**REQUEST for PARCEL SEGREGATION and BOUNDARY LINE ADJUSTMENTS**

SUBJECT: Hattlestad SEG/BLA

DESCRIPTION: Boundary Line Adjustment/Segregation in Forest & Range Zone

TO: Community Development Services  
FROM: Randy Carbary, Planner II *rc*  
DATE: July 25, 2006  
SUBJECT: Hattlestead Investments, Inc. SEG-06-92, 19-17-23000-0005

PART OF THE NORTH HALF OF SECTION 23, TOWNSHIP 19 NORTH, RANGE 17 EAST, W.M.

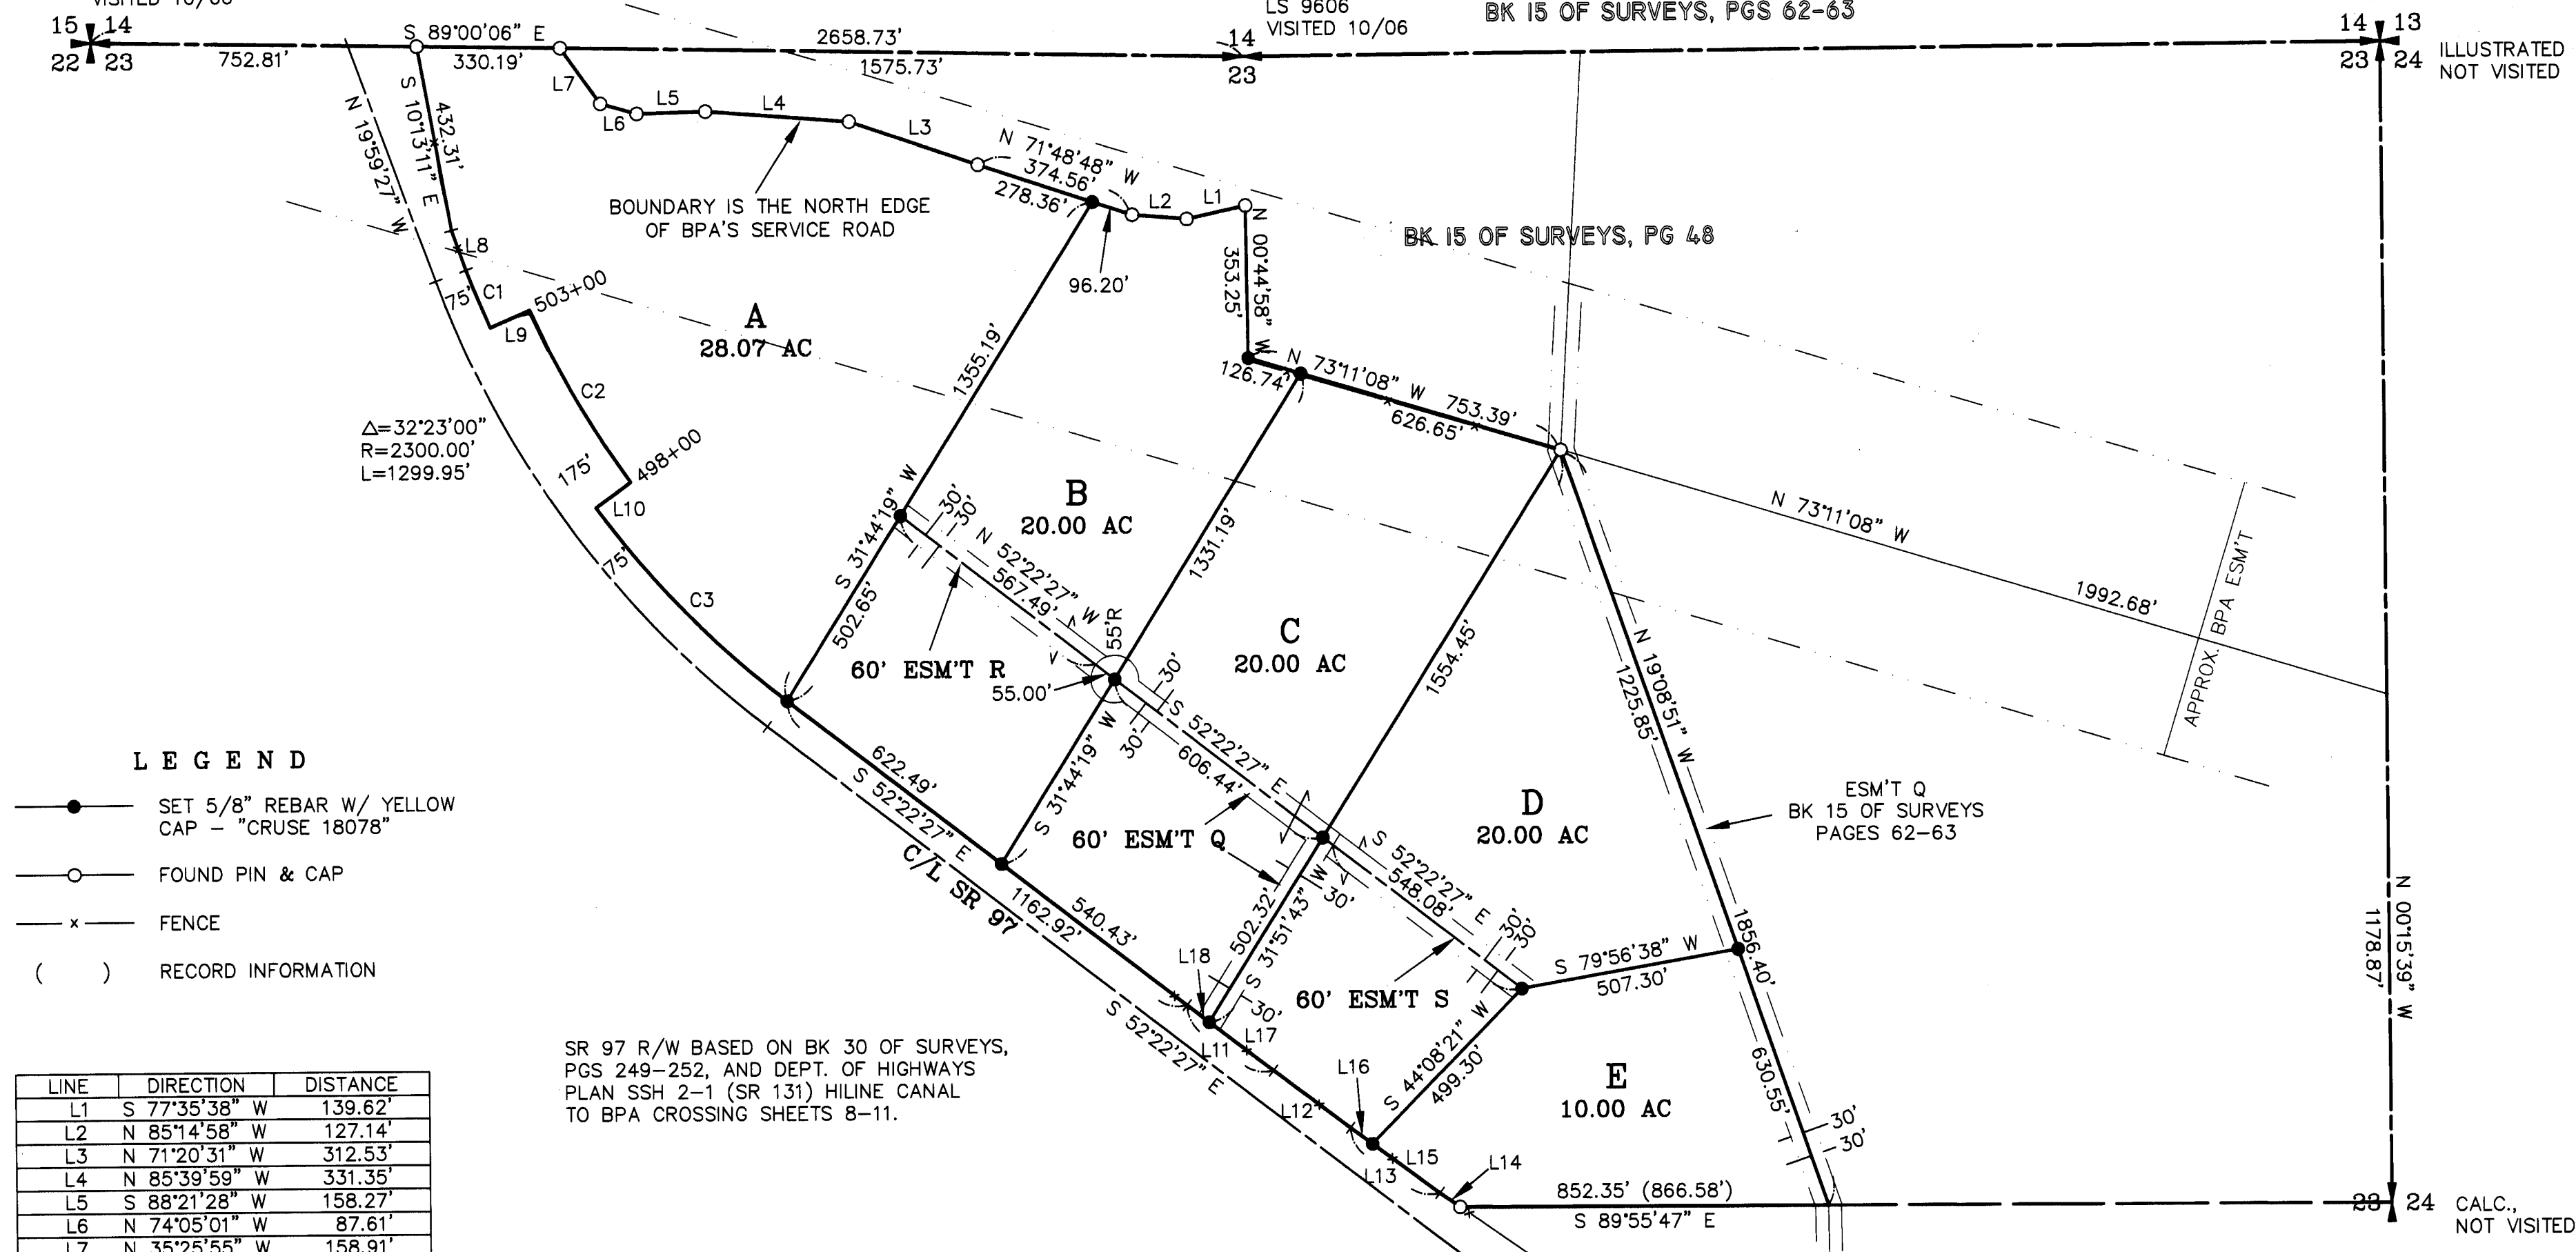
1. A legal description or survey of the Boundary Line Adjustment reflecting the new acreage and lot dimensions must be submitted to our office and reviewed for final approval.
2. Full year's taxes need to be paid for all tax parcel numbers per requirement of the Kittitas County Treasurer's office.
3. Please refer to the attached Kittitas County Public Works Memo for additional information regarding additional requirements.

1. Prior to final approval the proposed access with appropriate easement(s) shall be shown and shall conform to applicable Kittitas County Road Standards.
